Submission for: SSD-8996 Loreto Normanhurst School Redevelopment (Concept Proposal and Stage 1)

OBJECTION

Janette Cowell
Normanhurst NSW

2 SITE ELEVATION - MOUNT PLEASANT AVENUE
1:500

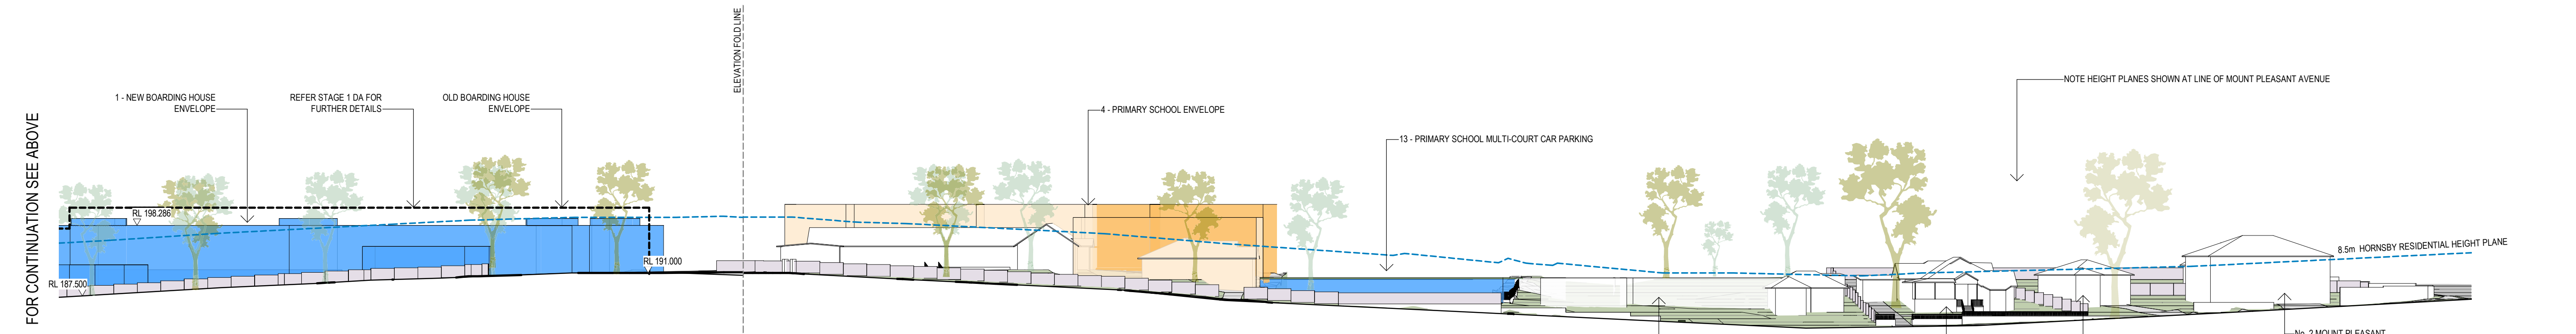
- a) Mt Pleasant Avenue has a maximum of 8.5 m building height according to Hornsby Council LEP. The proposed Boarding House has an envelope of 22 m. A height of 22 m, together with the bulk and scale of an up to 6 storey Boarding House, will dominate the streetscape and impact badly on nearby properties and the enjoyment of the street in general. Higher buildings should be placed away from the perimeter and residents' houses.

- b) There has been little concern put into the aesthetics of the Boarding House from the Mt Pleasant aspect, being a large bulky building with little room for screening. On the other hand, the westerly aspect of the Boarding House facing Loreto's current oval has been thoughtfully designed and is much more pleasing. Mt Pleasant residents feel they are getting the services and 'rear' of the building.

- e) *Suggestions: reduce height of boarding house and design to complement the streetscape.*
